16 November 2012

RE: Submission in response to the Environmental Assessment on the Cobbora Coal Project

Your Ref: Application Number 10_0001

Proposed Road Closures and Realignment for Mine Operations

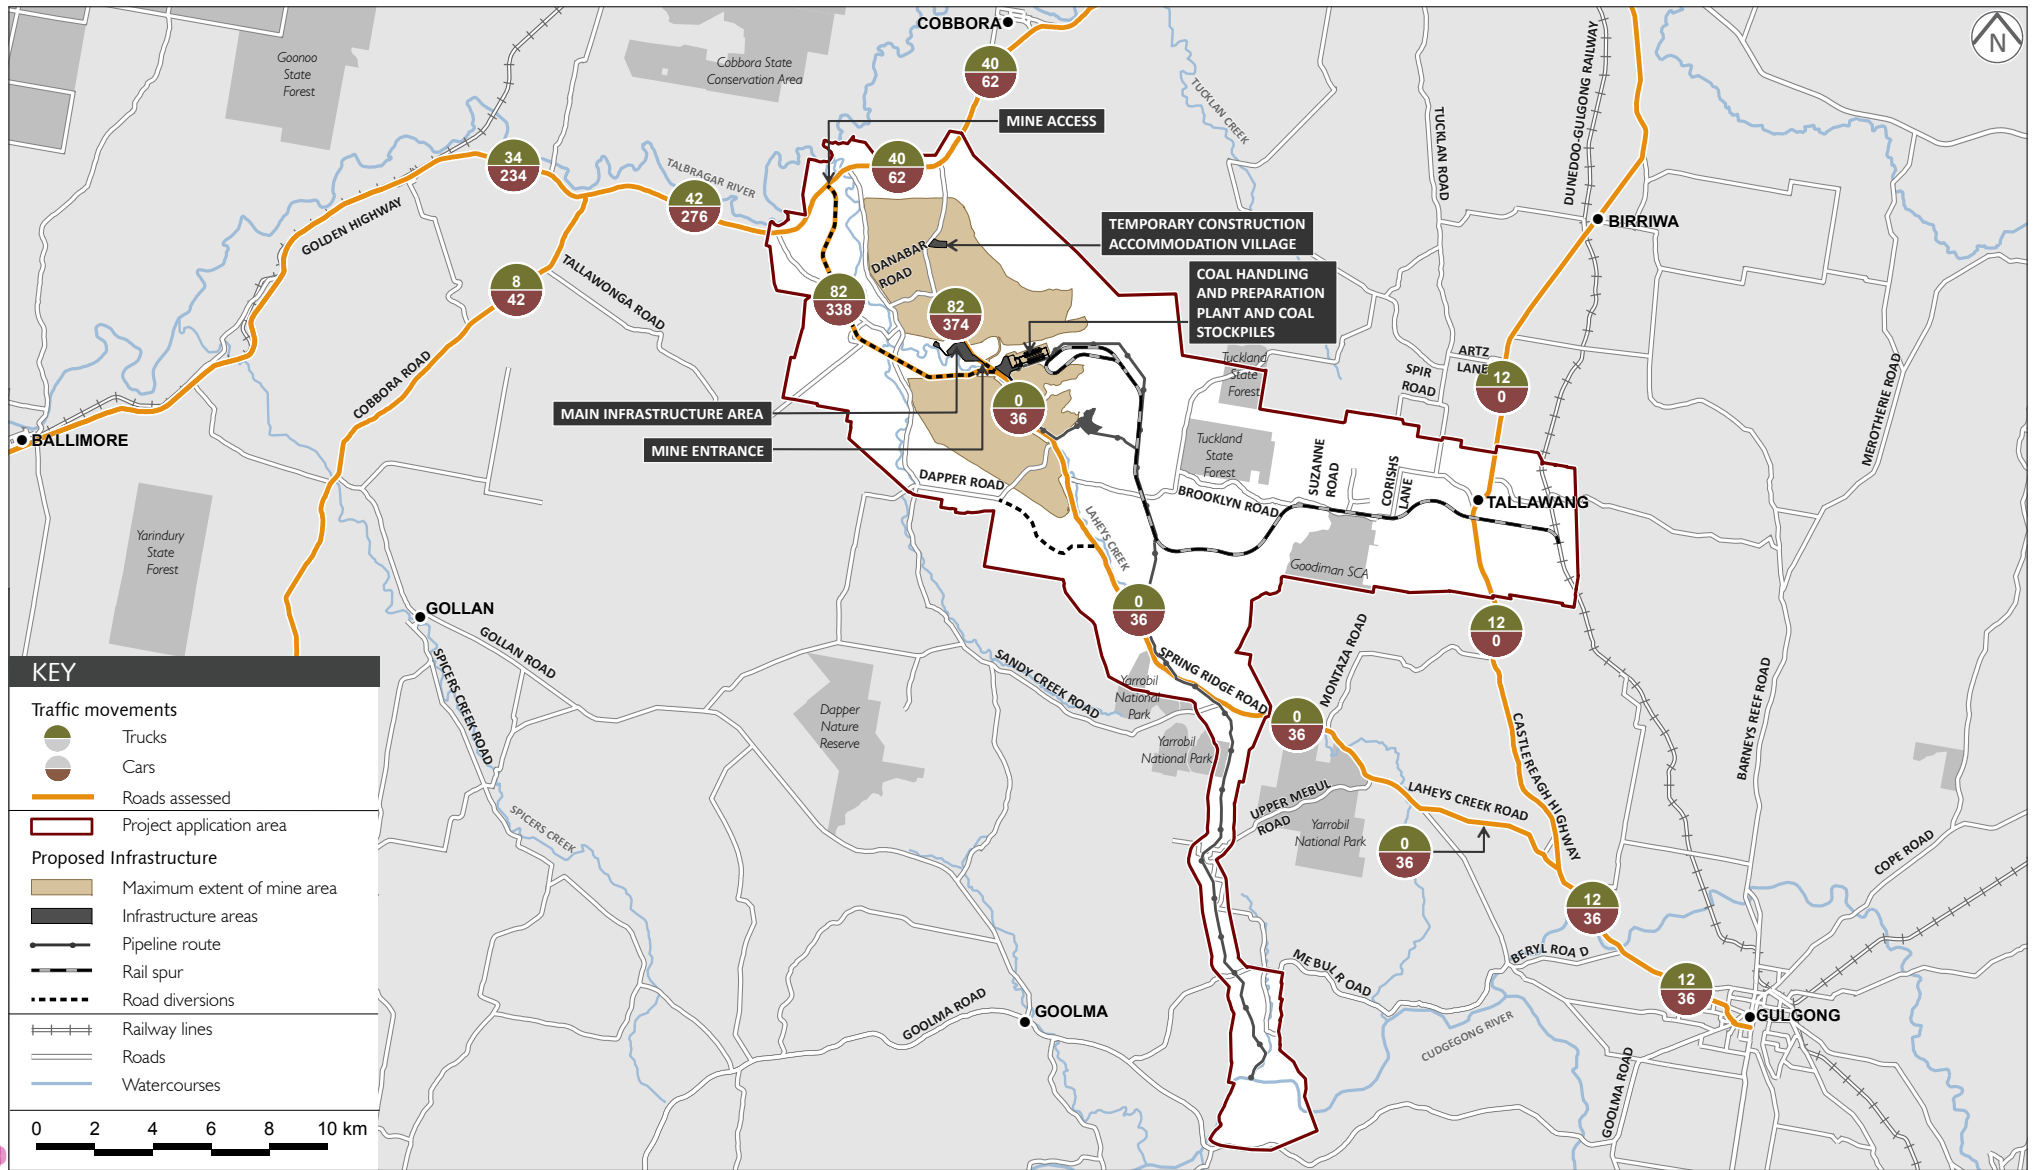
THE FIRST 8.13 KM OF SPRING RIDGE ROAD HAS A CURRENT ASSET VALUE OF \$1.4 M IN COUNCIL'S ADOPTED ASSET MANAGEMENT PLAN AND THOUGH IT WILL BE RECONSTRUCTED AT THE PROPONENTS EXPENSE THE NEW ASSET WILL BE WITHIN THE WELLINGTON LGA AND COUNCIL WILL HAVE LOST AN ASSET. COUNCIL REQUIRES THE ASSET TO BE ACQUIRED BY CHC AT ITS CURRENT VALUE.

The first 8.13 km of Spring Ridge Road south of the Golden Highway will be closed as a public road when the Spring Ridge Road Realignment is completed. The applicant shall apply for and pay all costs associated with the closure.

When the Spring Ridge Road Realignment is opened and the construction traffic has essentially stopped the intersection with the Golden Highway will be removed and the section of Spring Ridge Road back to the highway easement fence line restored to blend with the surrounding environment. All signage associated with the intersection shall be removed.

Sandy Creek Road

The section of Sandy Creek Road between the Golden Highway and the Spring Ridge Road Realignment will be closed as a public road when the Spring Ridge Road Realignment is completed. The applicant shall apply for and pay all costs associated with the closure.

When the Spring Ridge Road Realignment is opened and the construction traffic has essentially stopped the intersection with the Golden Highway will be removed and the section of Spring Ridge Road back to the highway easement fence line restored to blend with the surrounding environment. All signage associated with the intersection shall be removed.

Consideration should be given to the removal and restoration of that section of Sandy Creek Road not within the mine footprint.

Council requires a rail overpass not a road underpass to accommodate the rail spur line .Details are to be submitted to Council for approval.

Daily Operations Traffic Movements

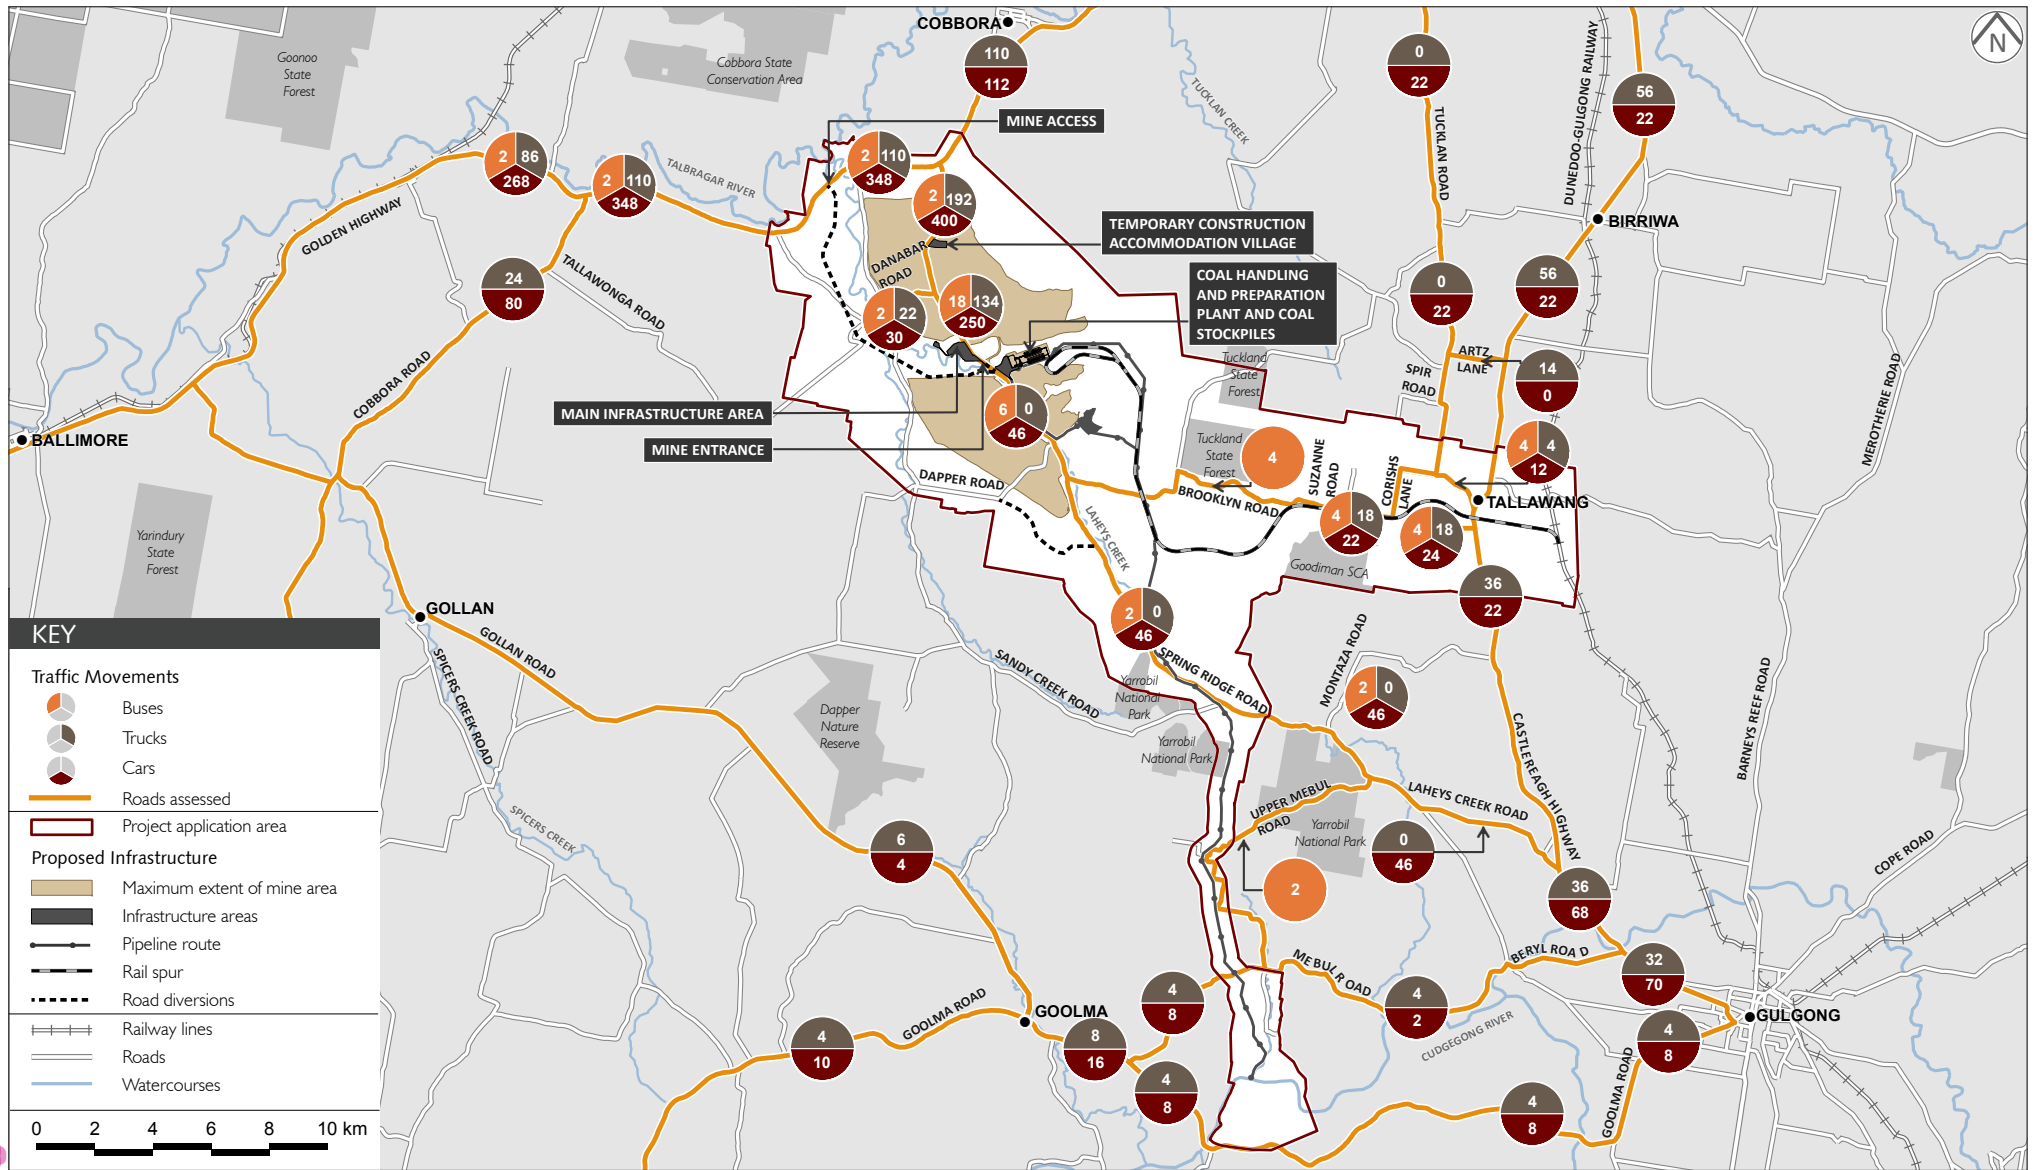
Traffic Volumes

It is Council's opinion that during construction the daily traffic flows is likely to be:

- (a) 155 mine worker cars
- (b) 60 cars associated with the accommodation facility
- (c) 35 visitor cars
- (d) 100 trucks

This equates to 350 vehicles per day including 100 trucks impacting on local roads.

During the operational phase there will be 291 vehicles per day including 41 trucks impacting local roads.

It is Council's view that the traffic impacts are understated in the EA and therefore this work needs review.
